# *City of Albuquerque*

**RE: *Grading and Drainage Plan for Aloha R.V./Trucks Unique (C18/D14) Submitted for Site Development Plan for Building Permit Approval, Final Plat and Building Permit Approval, Engineer's Stamp Dated 3/1/00.***

**RE: *Grading and Drainage Plan for Aloha R.V./Trucks Unique (C18/D14) Submitted for Site Development Plan for Building Permit Approval and Building Permit Approval, Engineer's Stamp Dated 12/23/99.***

Re: Site Plan/TCL submittal for building permit approval for Aloha R.V./Trucks Unique, \_ \_ \_ Carmel  
N.E. (At Wyoming), North Albuquerque Acres, Tract A, Block 16, Lots 8-10 and 22-25.  
No Engineer's Stamp dated or signed. [C-18/D014]

GRADING PLAN

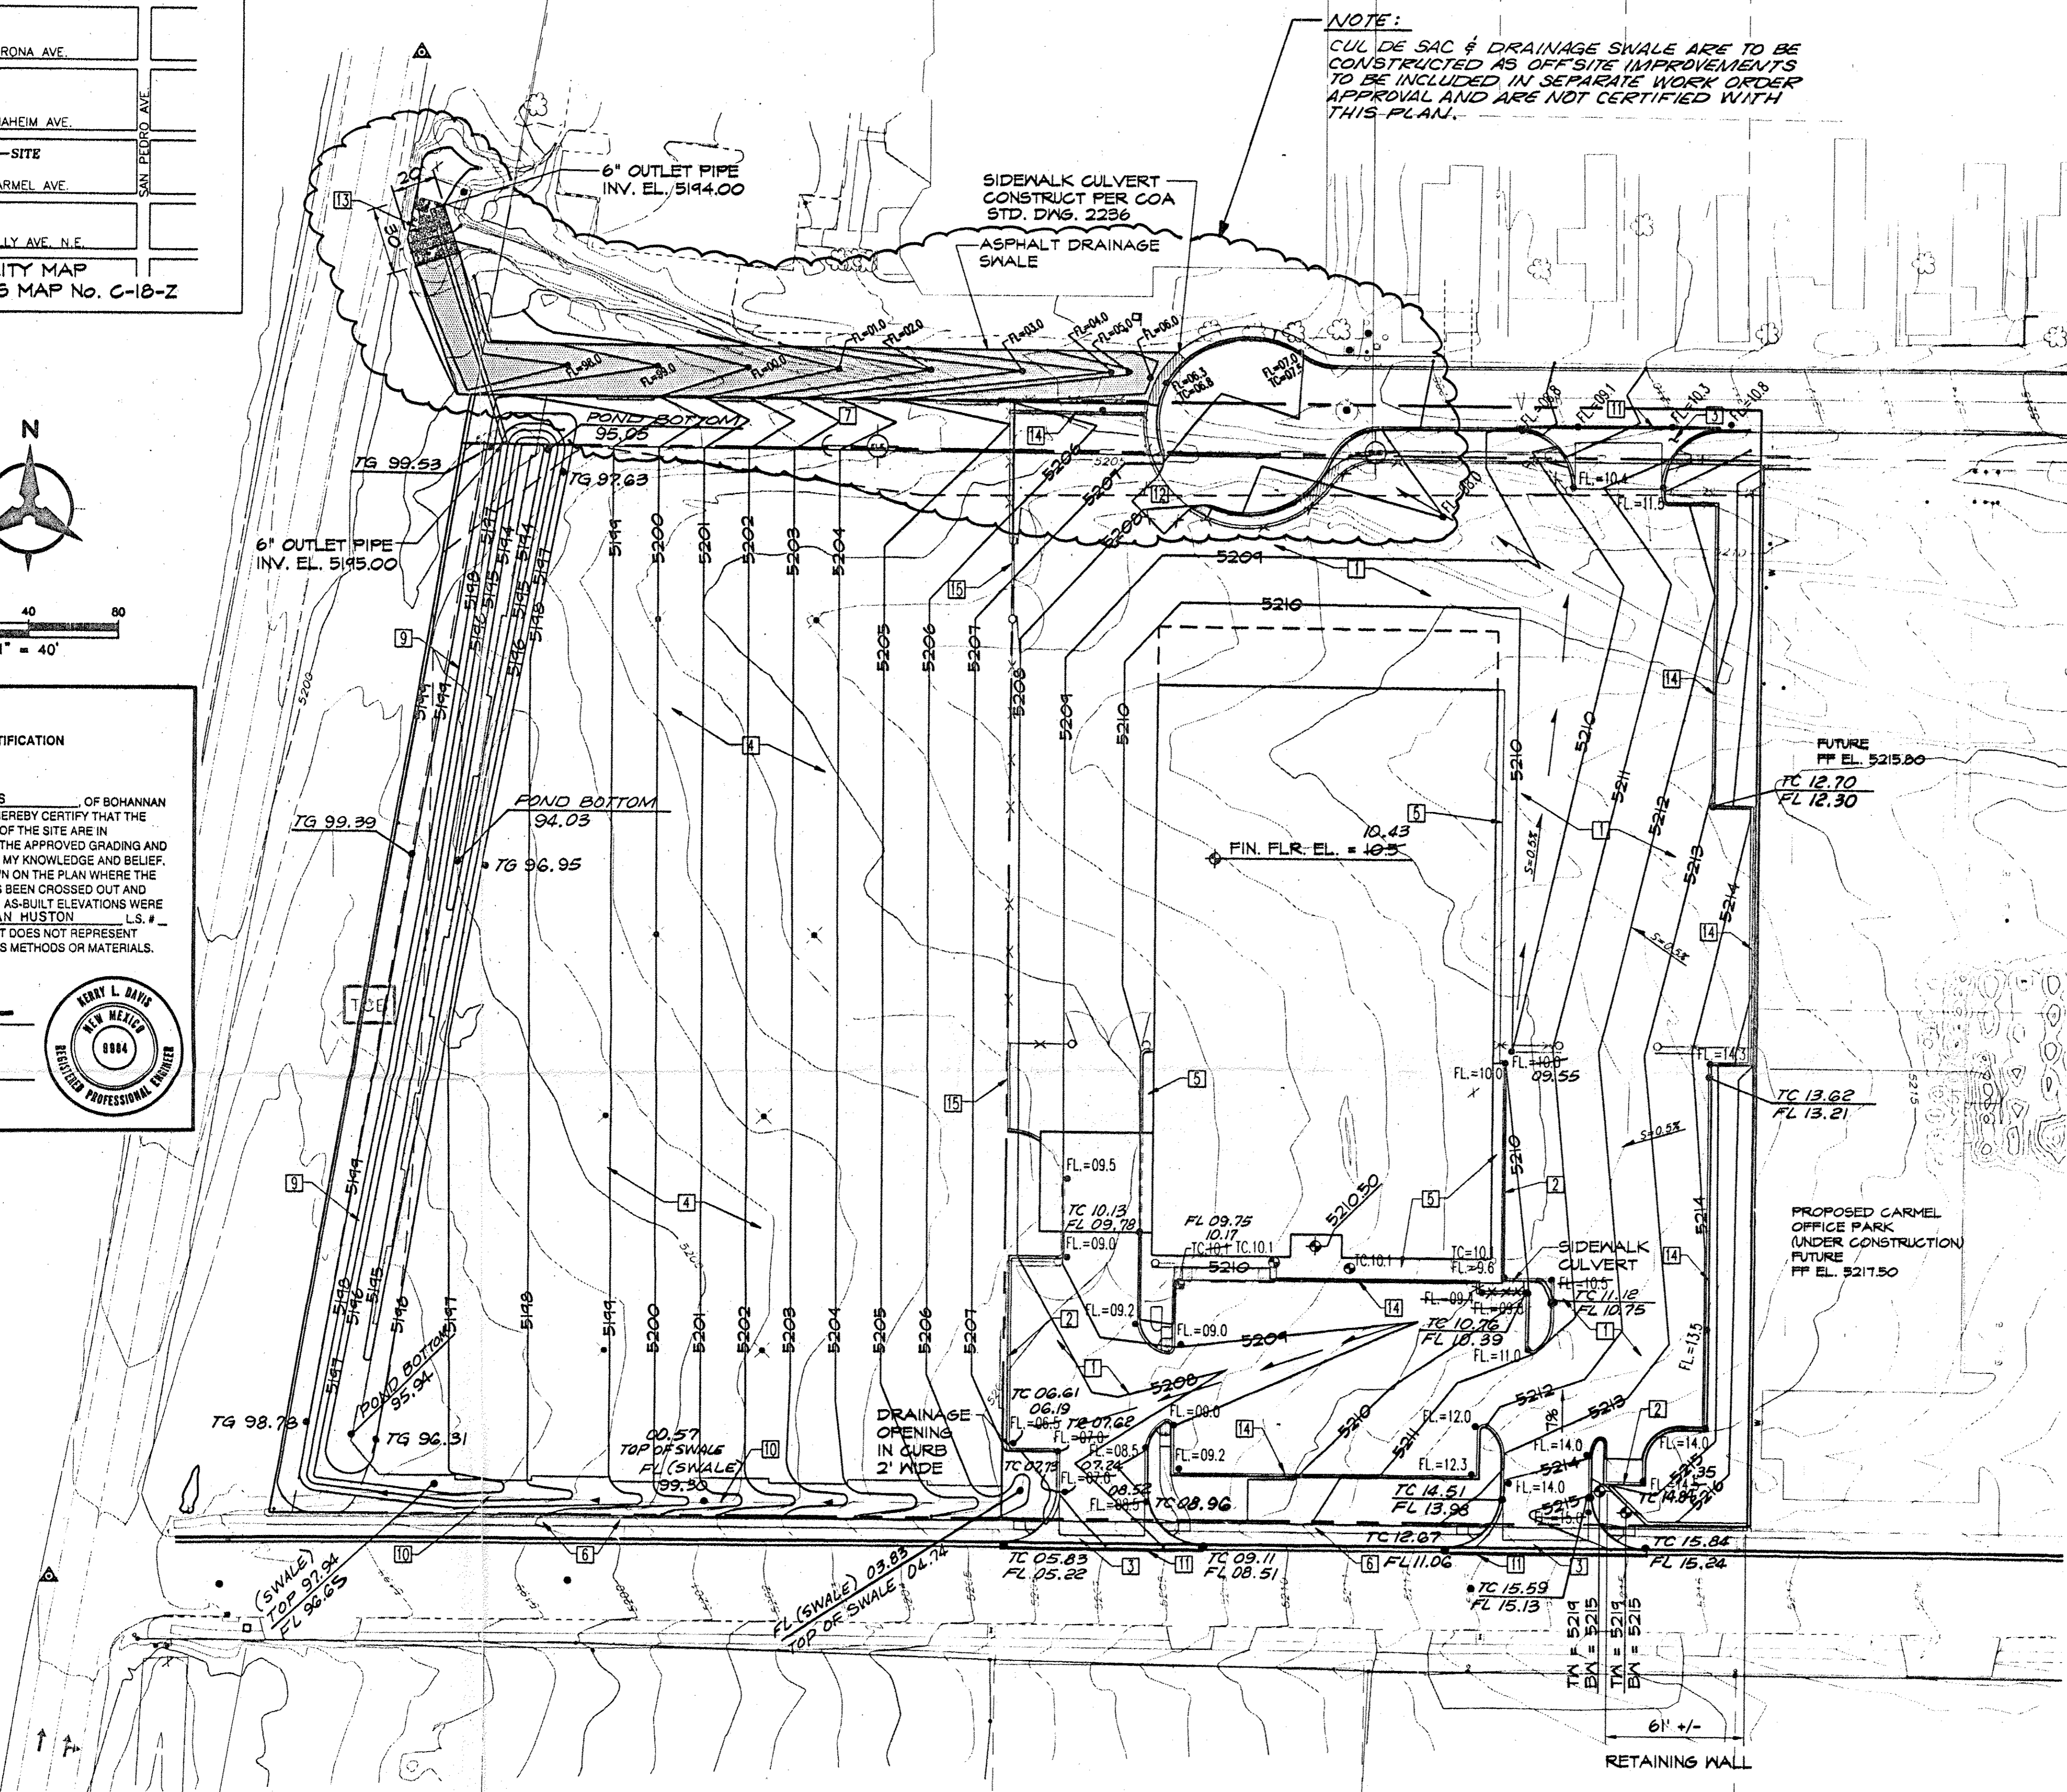
Based on the information provided on March 2, 2000, the above referenced plan is approved for Site Development Plan approval by the DRB. However, the proposed asphalt swale must be incorporated into your site. It is unclear from the plan whether this swale is located within your property or on the property to the north. This issue must be resolved prior to Final Plat sign-off.

1. Permission must be obtained from the Highway Department for the proposed connection to the I-25 box culverts within their right-of-way. Please provide a copy of the state's approval letter with your resubmittal.
2. An Agreement and Covenant is required for the proposed asphalt drainage swale. This document will state that the swale will be maintained by the underlying property owner, and not by the City.
3. At this time, there is no approved plan for the Carmel Office Park, and the master drainage plan for this area, by Wilson & Company, has not yet been approved. Prior to Building Permit release, please check to see whether a retaining wall is required along your east property line to direct any off-site runoff towards Anaheim.

3. The plan shows a retaining wall along the east property line to be constructed by others, however, the plan for Lot 12 did not propose to build that wall at this time. Therefore, your plan must address the off-site flow condition in the interim, or you may build the wall.

4. Please coordinate with the development to the east regarding proposed grades along your east property line. Provide existing and/or proposed spot elevations adjacent to your site.

5. The plan shows a proposed 20' asphalt channel to be constructed within the "public drainage and utility easement". On section A-A please show the existing utilities through this easement. Is AMAFCA's outfall pipe located in this easement? It appears that this easement is partially located on private property. Please identify the property lines and easement limits on the plan. The proposed channel should be located within the vacated road right-of-way.

7. Existing street grades were not provided for Carmel or for the portion of Anaheim east of the site. Are the required one-foot water blocks provided at each entrance?
8. Provide existing spot elevations west of the site to show how the proposed grading will tie in.
9. It appears that Mike Zamora has provided comments regarding the traffic circulation layout. Since the site plan must be approved by DRB, transportation comments will be addressed at that time.

DRAINAGE PLAN

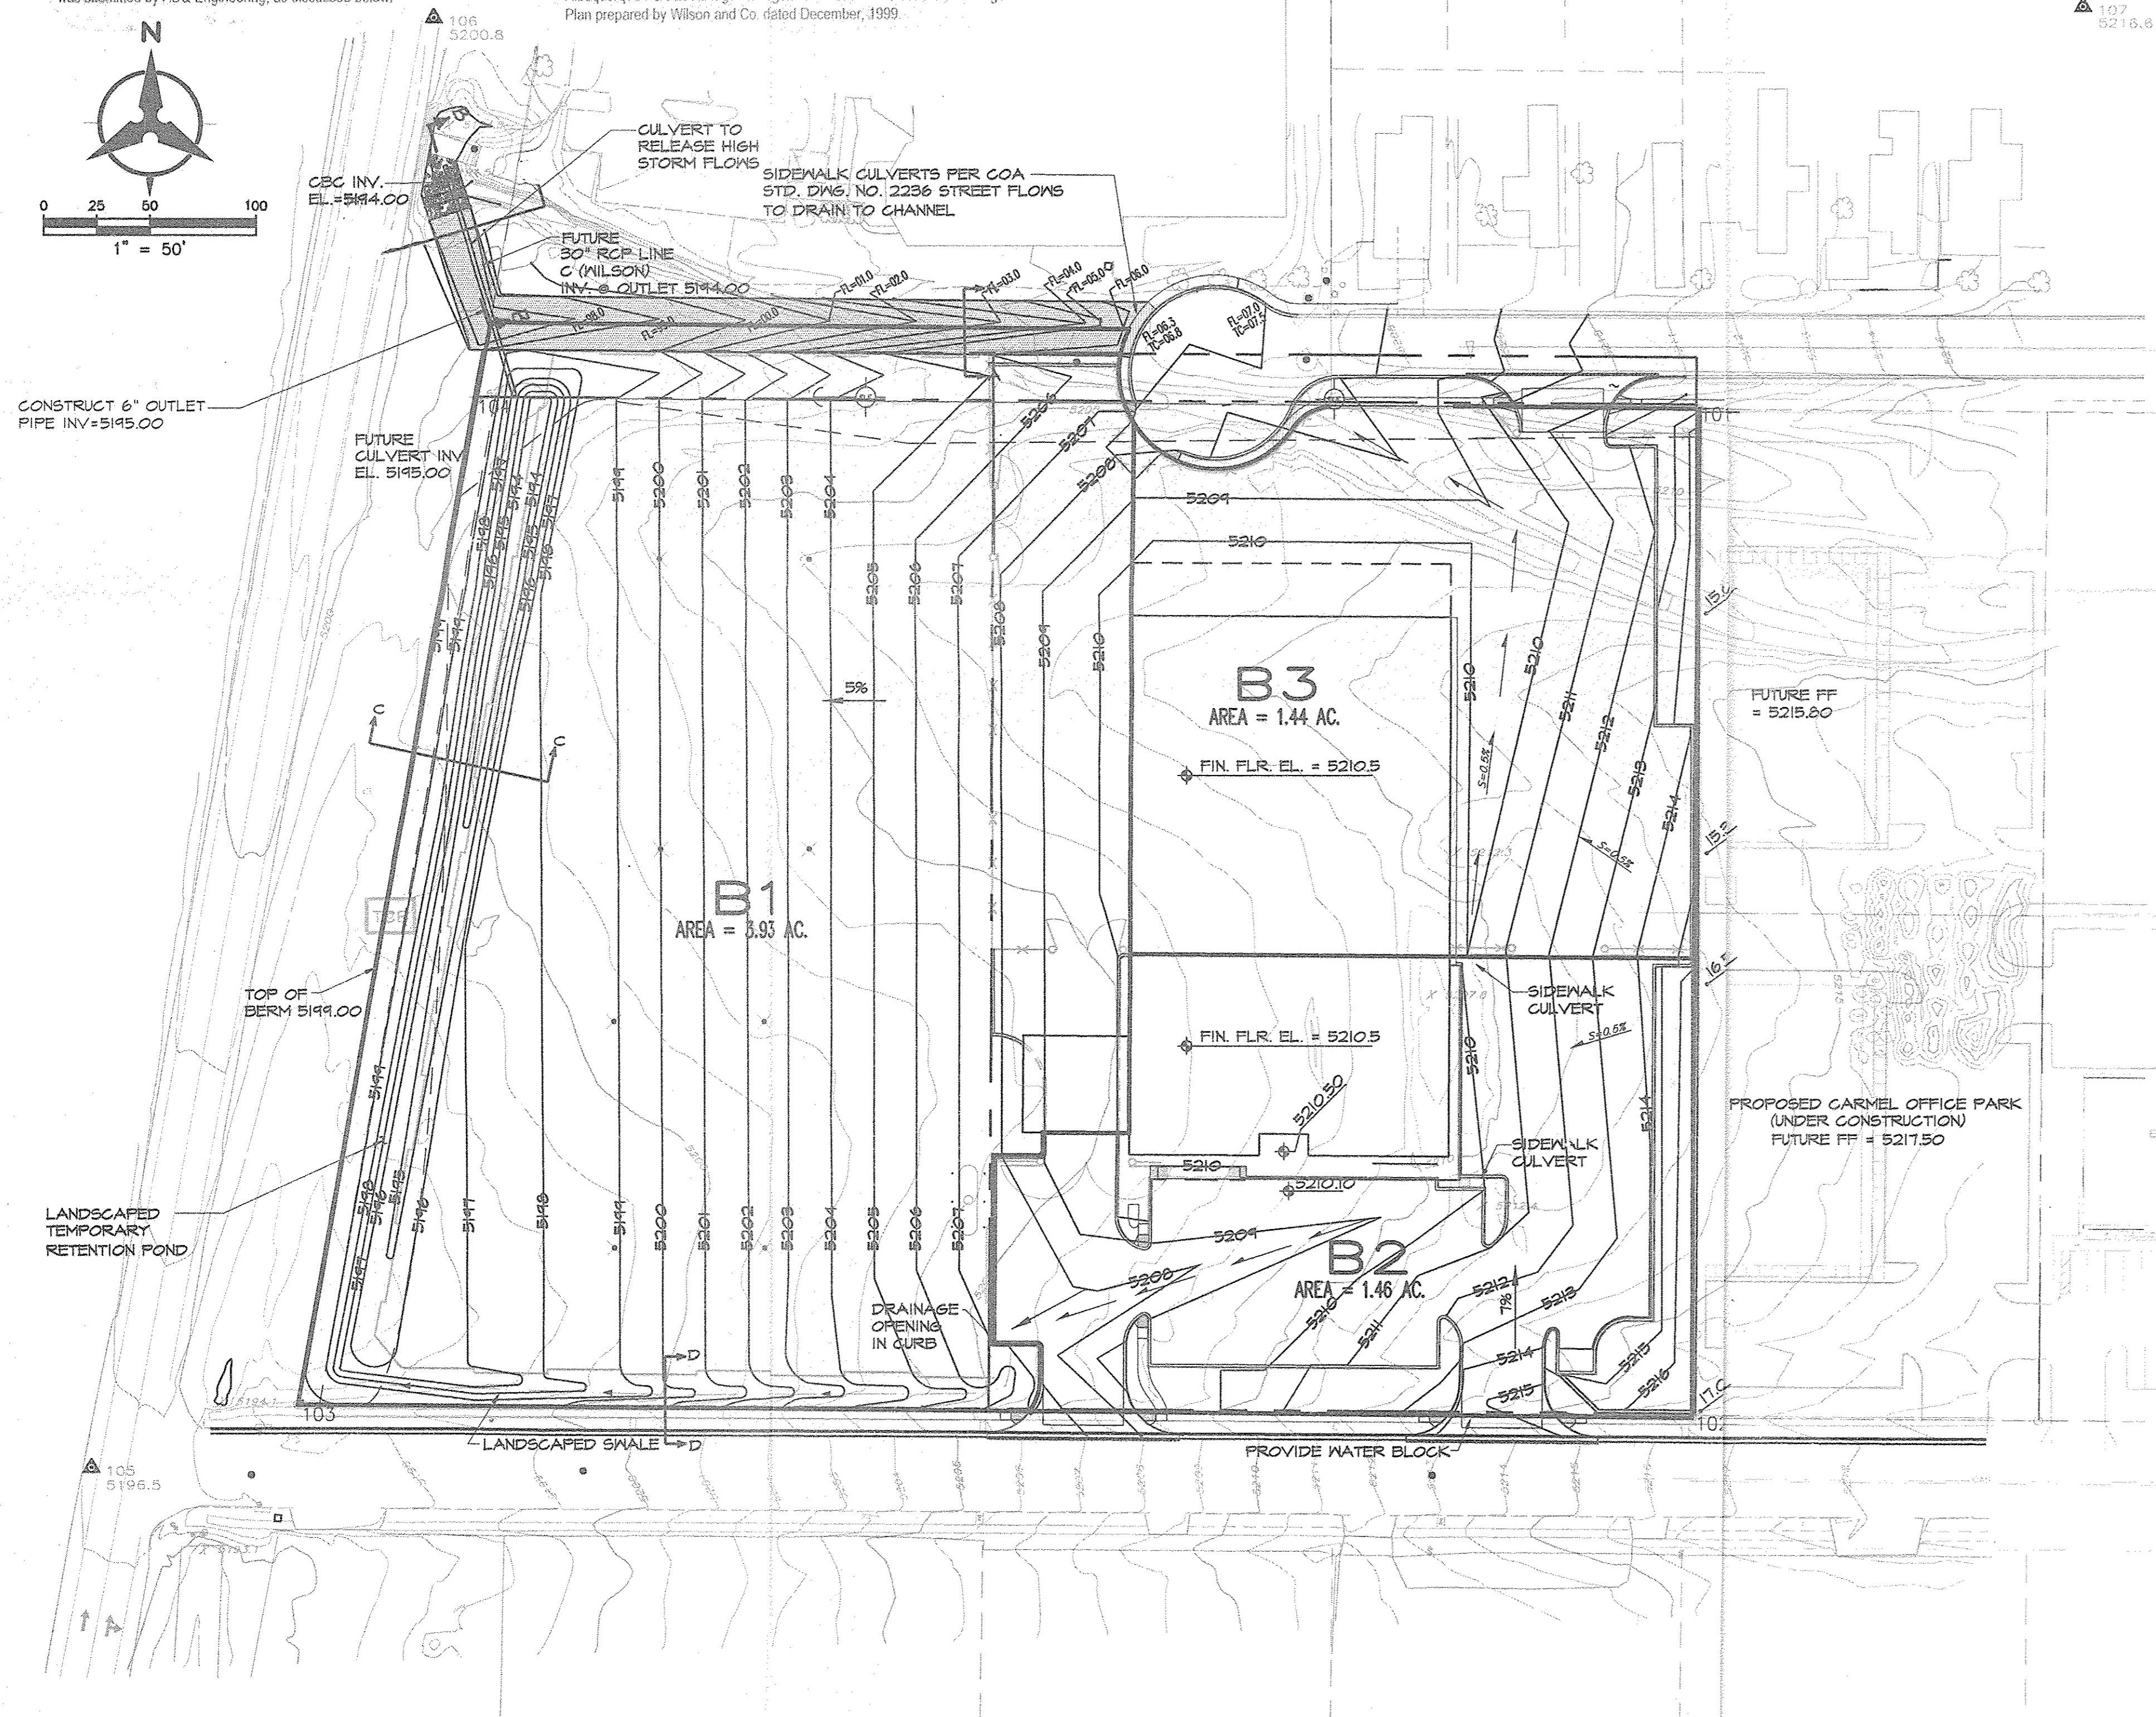
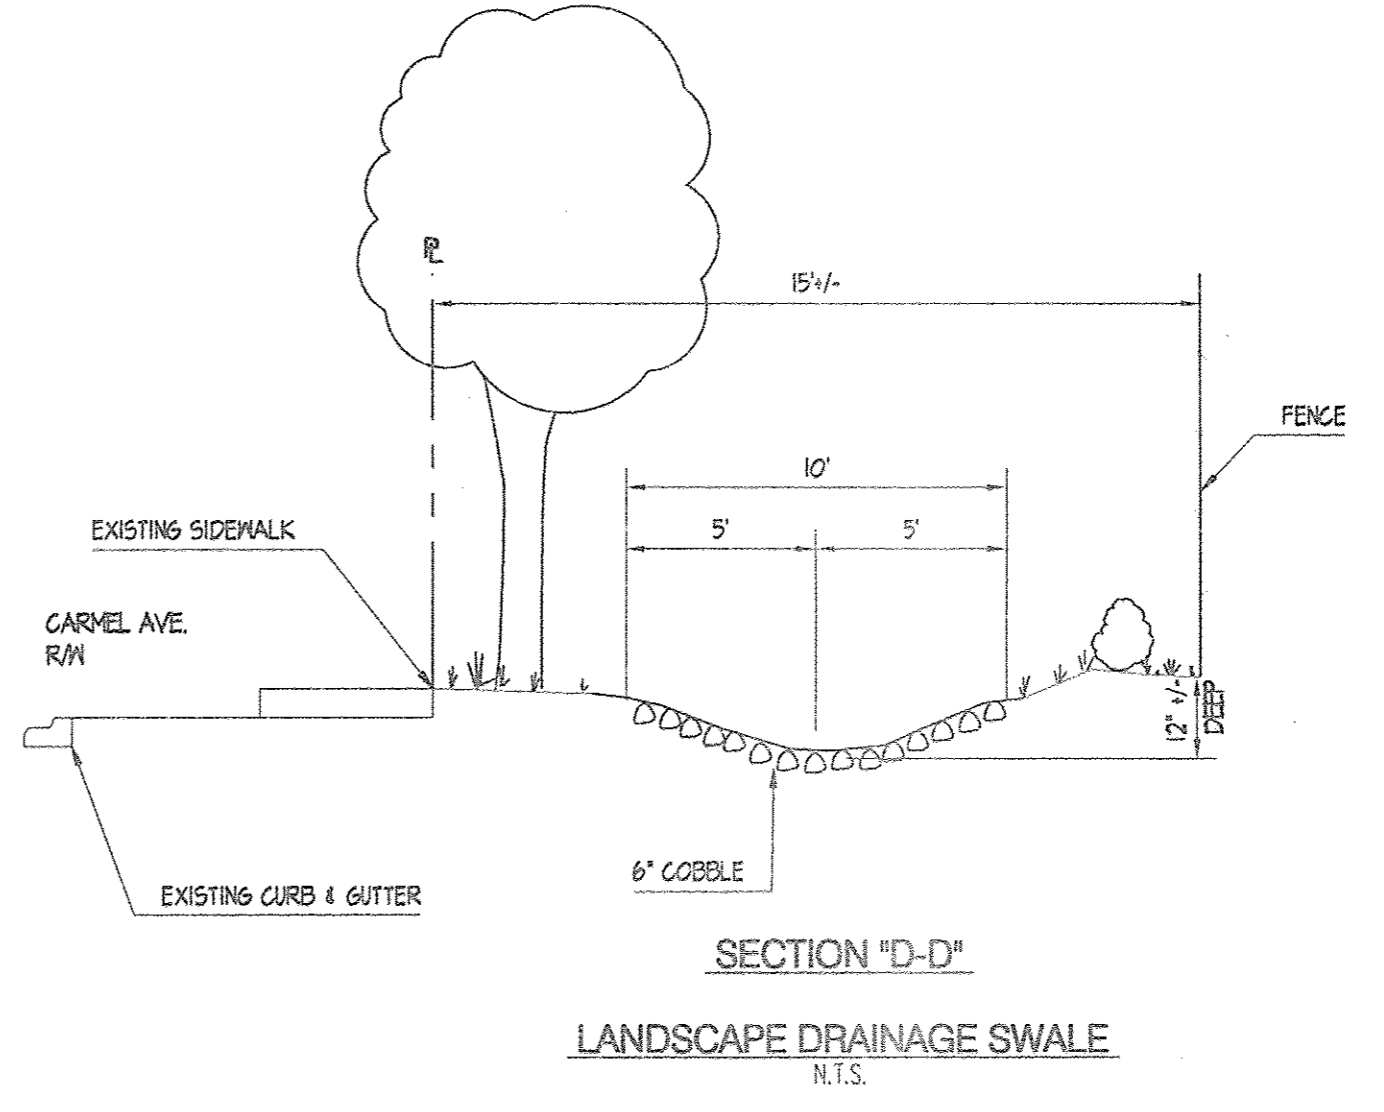
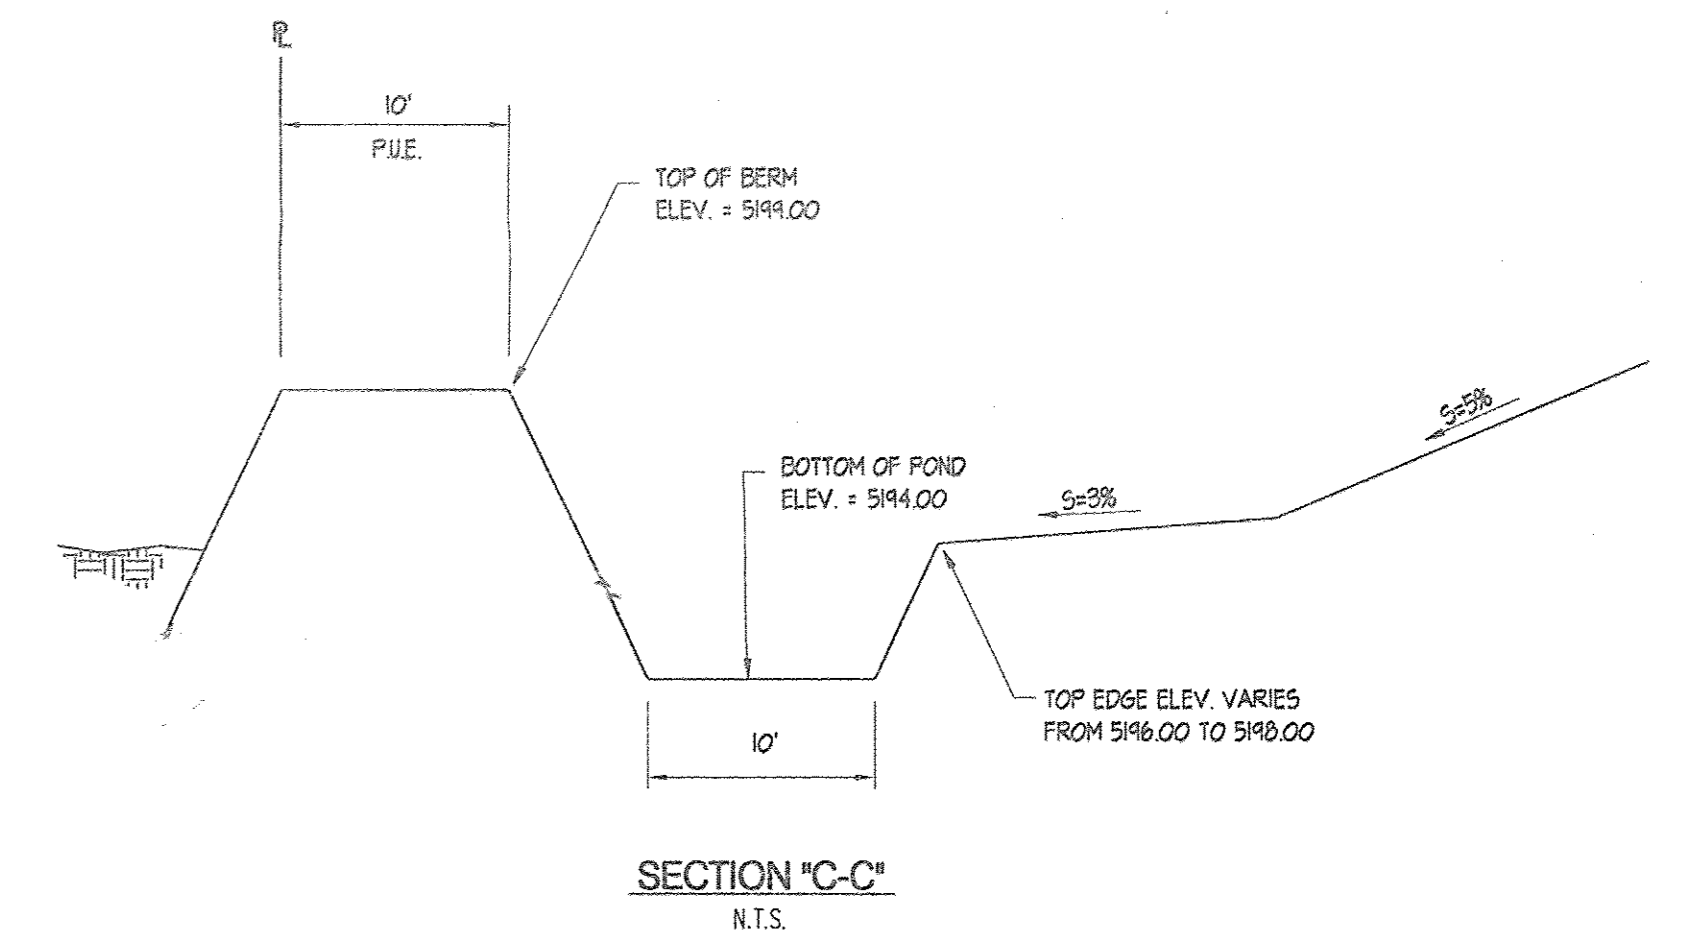
6. Where is basin A3 located?
